Application Ref:	3/2026/0140			 Ribble Valley Borough Council www.ribblevalley.gov.uk
Date Inspected:	20/03/26	Site Notice:	20/03/26	
Officer:	LW			
DELEGATED ITEM FILE REPORT:				APPROVAL

Development Description:	Proposed demolition of existing dwelling and replacement with one new dwelling (self-build), outbuilding and garage.
Site Address/Location:	Rose Hill Farm, Whalley Old Road, Billington, BB7 9JF.

Project Name	Rose Hill Farm	Project No.	219.25	Stage	Planning Submission
Proposed Floor Plans	09	Scale	1:100 @ A1	Date	January 2026
Rev	--	Drawn		RP

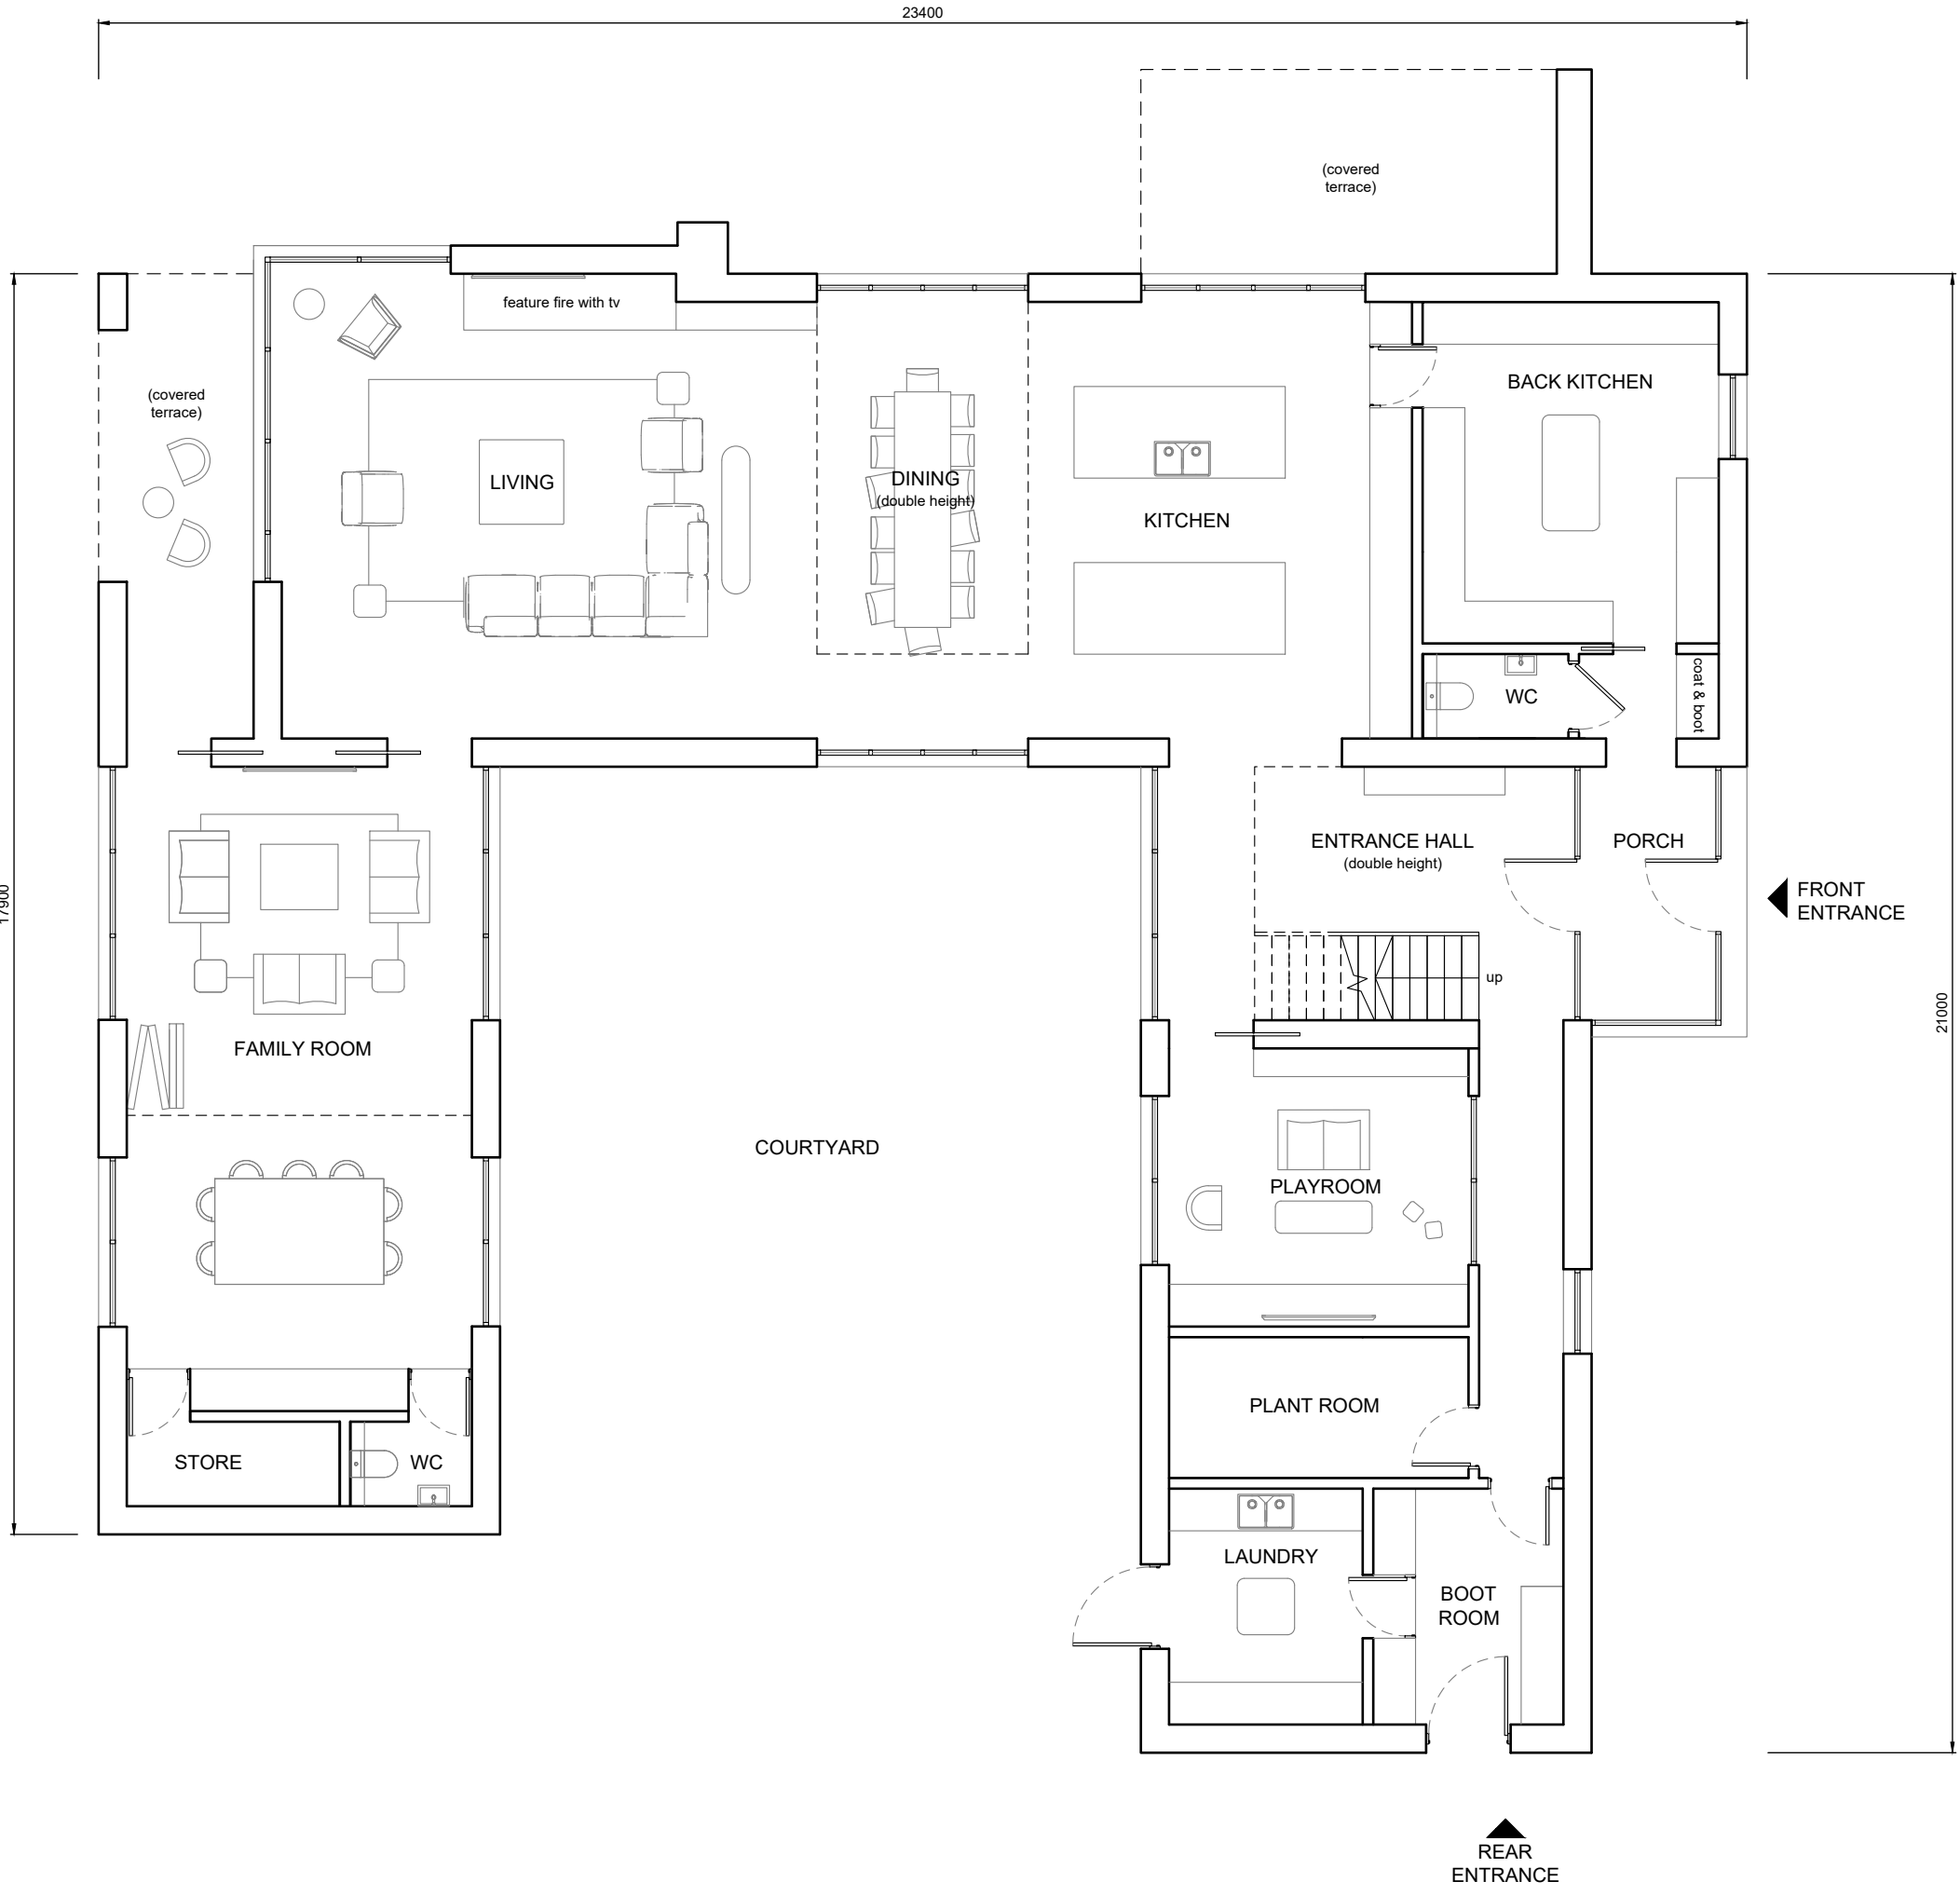
In comparison, the originally proposed replacement dwelling comprised a U-shaped configuration, with two pitched roof wings projecting from the south-eastern elevation to create a central courtyard area. One of the aforementioned wings was to be single storey in design but with a maximum height of 6m, whilst the two-storey element of the proposal comprised an L-shaped footprint measuring 23.4m by 21m with a maximum height of 8.7m. With this in mind, it was considered that the overall design of the development would result in dwelling which would appear significantly greater in both bulk and massing when compared to the existing property. It is acknowledged that the existing property and outbuilding are cumulatively large; however, within the context of the overall design of the proposed replacement dwelling, the additional size and scale (40% increase in volume from existing to proposed) would have been readily discernible, significantly extending the visual impression of built development at the proposal site. It was therefore considered that the proposal as originally submitted would appear 'materially larger' than that of the existing property.

The scheme as originally submitted comprised a large and architecturally complex dwelling, incorporating a U-shaped footprint with projecting gables, flat roofed linking elements, extensive areas of glazing and a varied palette of materials. Whilst contemporary design is not in itself unacceptable, the cumulative effect of these elements resulted in a building of considerable visual complexity and combined with its scale and massing, the dwelling would have appeared overly prominent and incongruous within this rural landscape setting.
